**Green Square Integrated
Community Facility & School**
3 Joynton Avenue
Zetland NSW 2017

**ACCESSIBILITY
REPORT**

Our Ref: AN020-215729
Date: 23/07/2021

GA PLAN - GROUND LEVEL

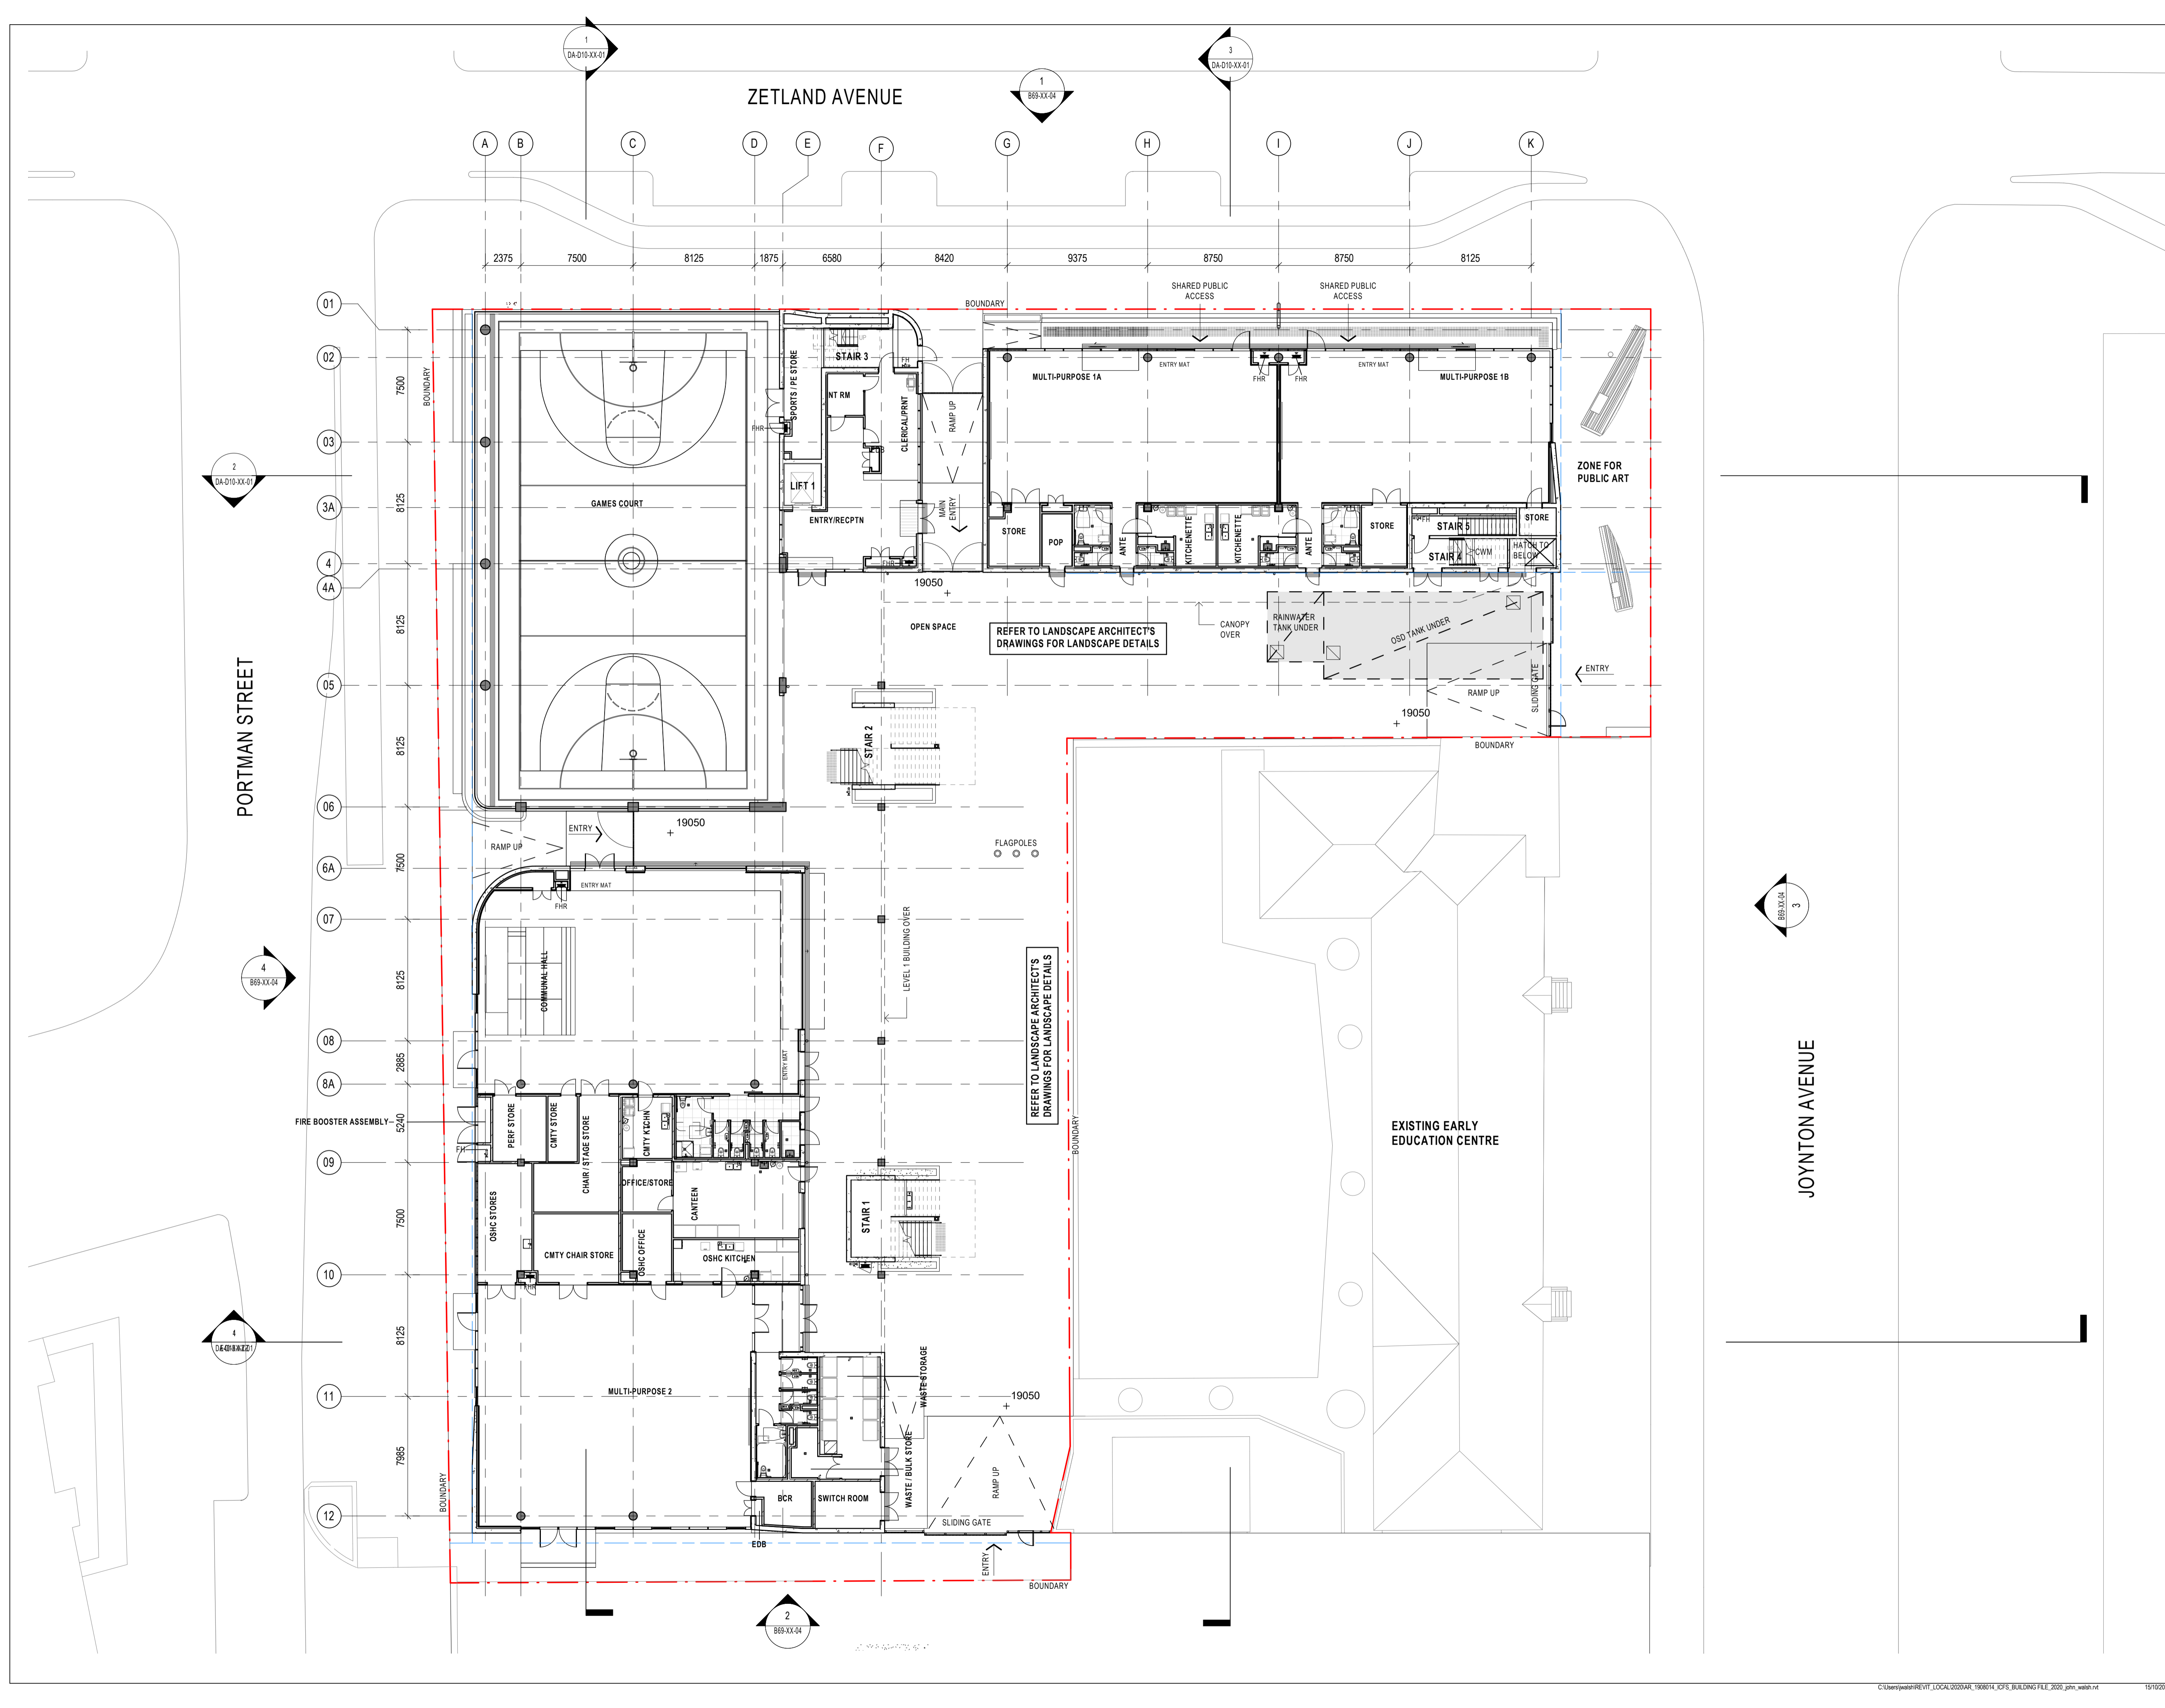
- a) There is a parallel accessible car parking space proposed on the ground floor, which needs to be provided with an adjacent shared zone of minimum 1.6m width by 7.8m length within the allotment boundary that is level/flush with the car parking space for compliance with AS2890.6-2009 as required by BCA D3.5.

- b) There are multiple doorways along required accessways on ground floor, levels 1 and 3 of the new school building that can be increased in door circulation spaces for manual operation and/or that can be on power operation or automation for compliance with AS1428.1-2009 and to provide access to and within all areas in accordance with BCA D3.1.

- d) An additional performance based solution is possible and may be required for handrail set outs on the external domain on the ground floor along northern Zetland Avenue boundary outside Multipurpose 1A and 1B.

1.	Access from the Allotment Boundary. The BCA requires that a continuous accessible path of travel be provided from the allotment boundary at the main points of pedestrian entry to the main entrance.	Can Comply	Complies in Principle There are multiple ramps intending to provide continuous accessible paths of travel respective pedestrian entry points to various building entrances.

GA PLAN - LEVEL 01

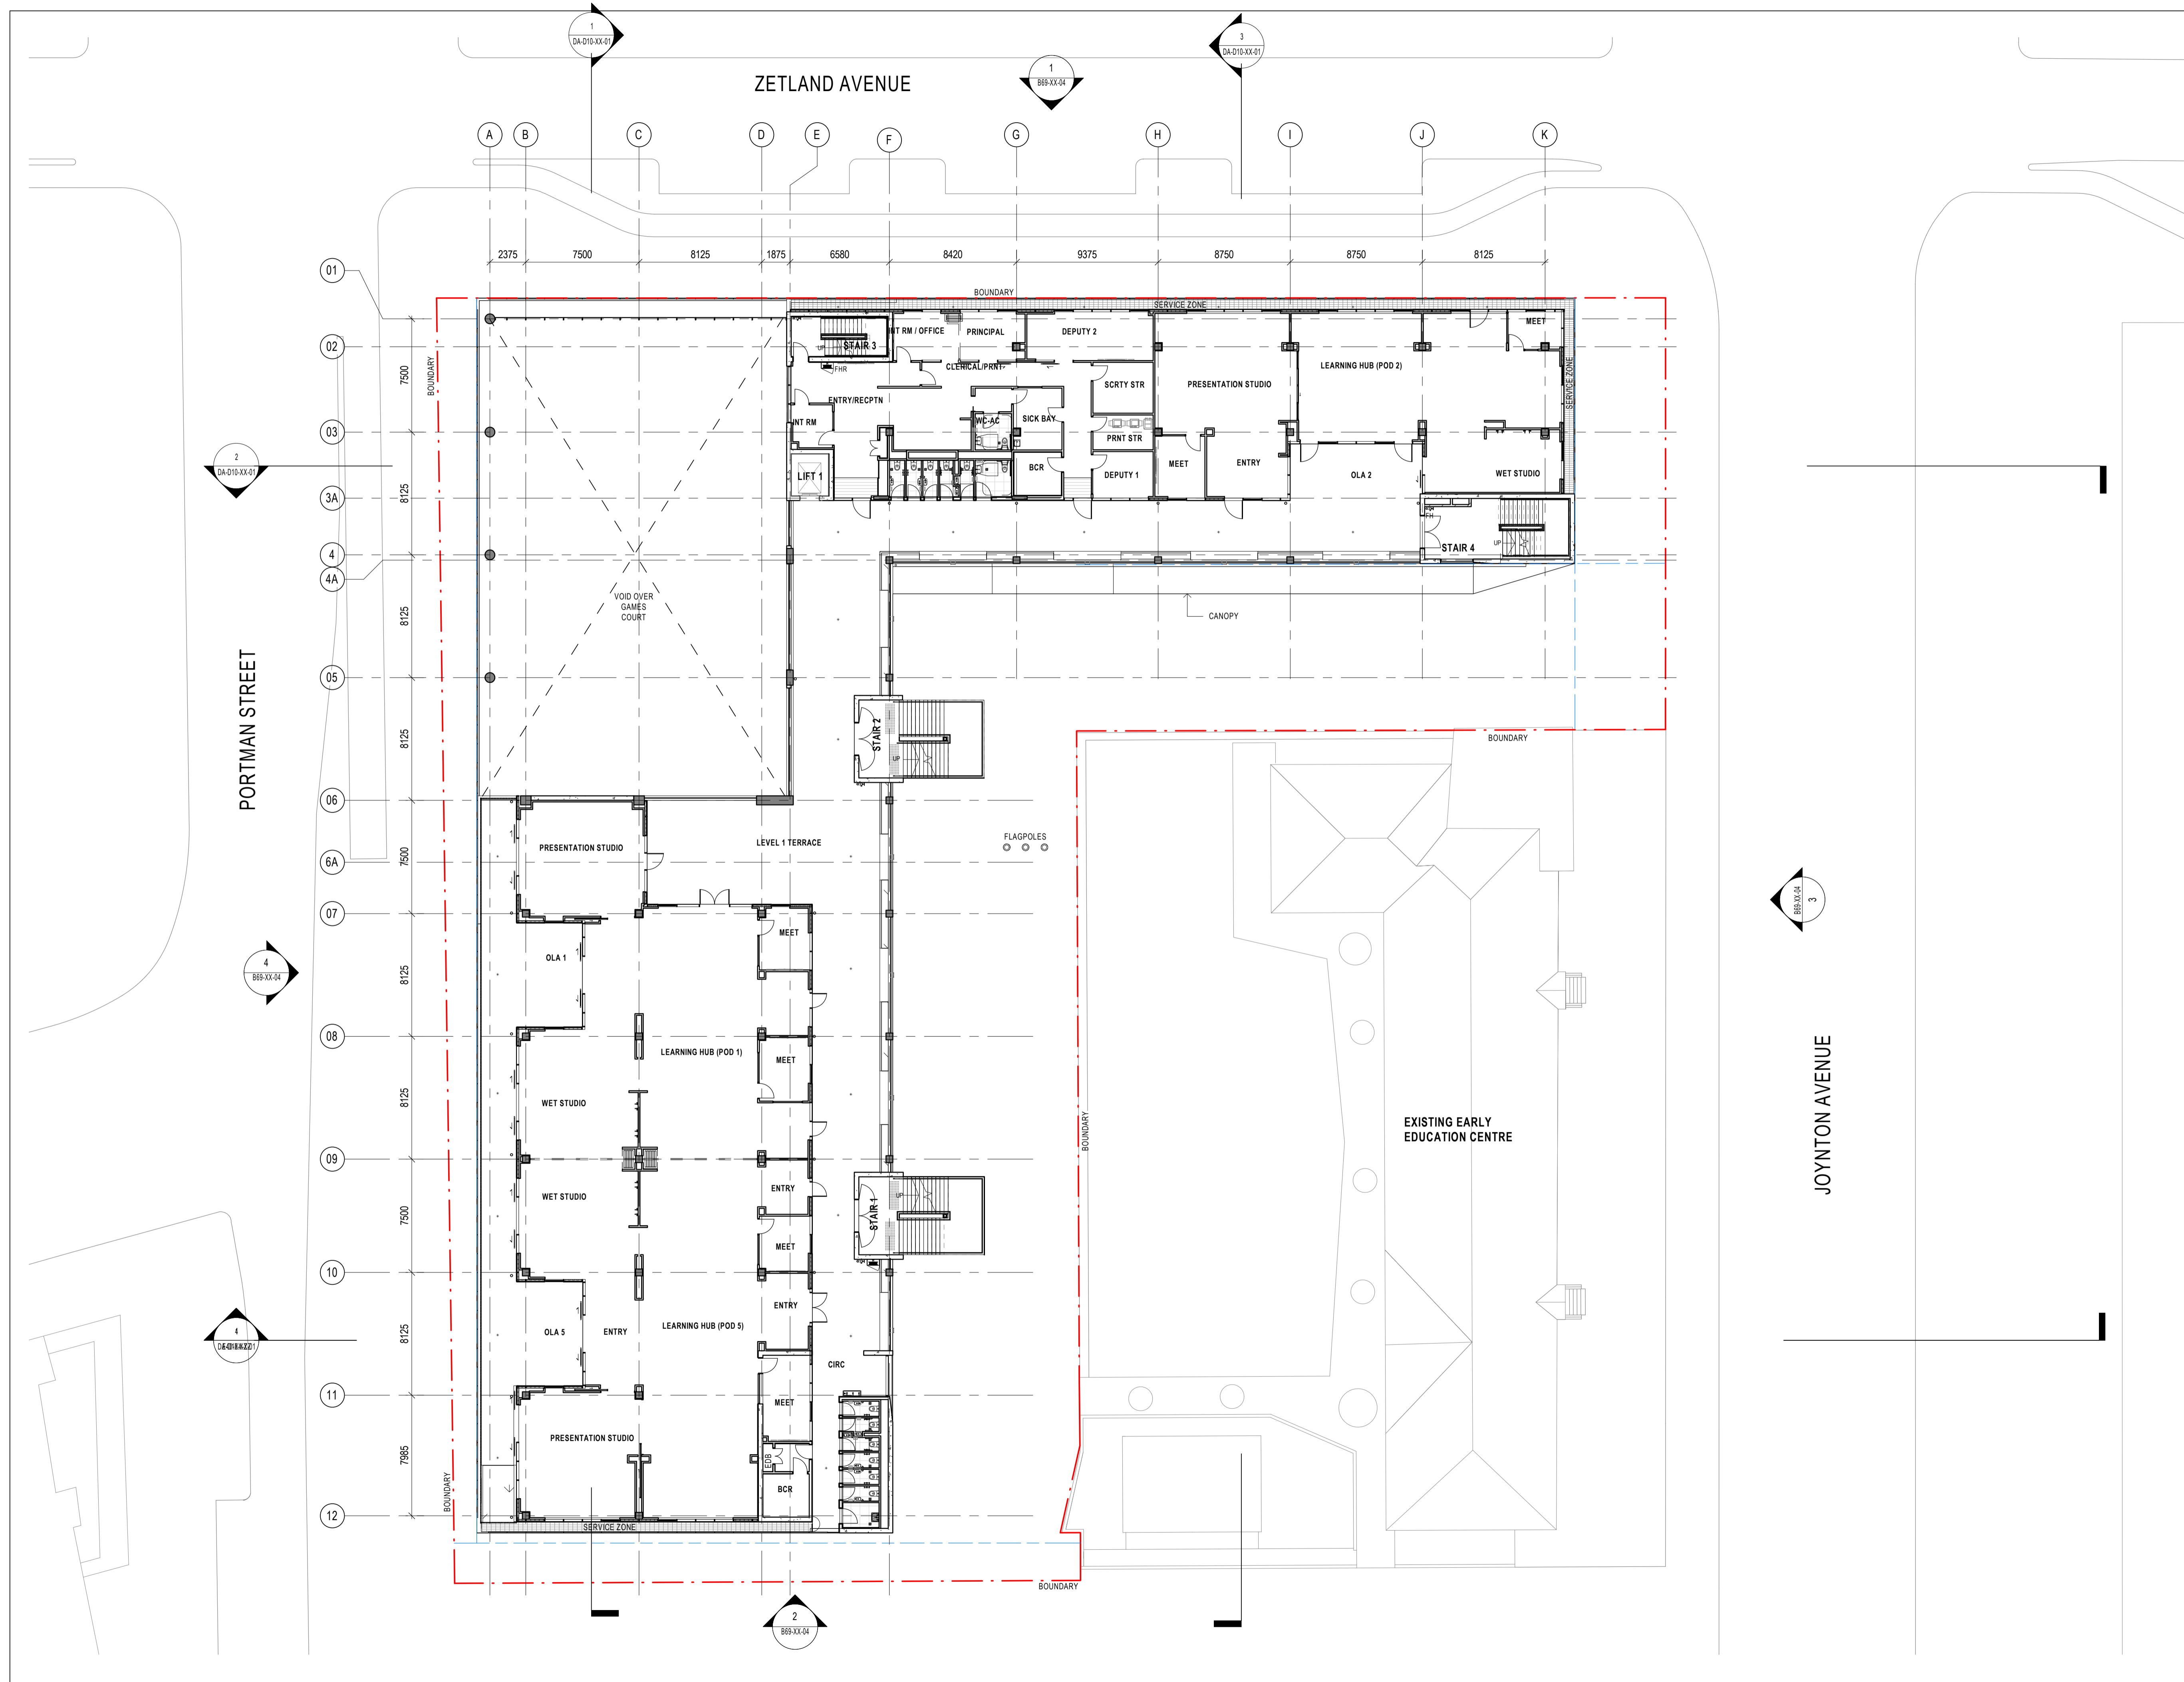
- f) There are two unisex accessible sanitary compartments provided on level 1 of the new school building that can be modified to achieve an even balance of Left Hand and Right-Hand Transfer toilet facilities in accordance with BCA F2.4.
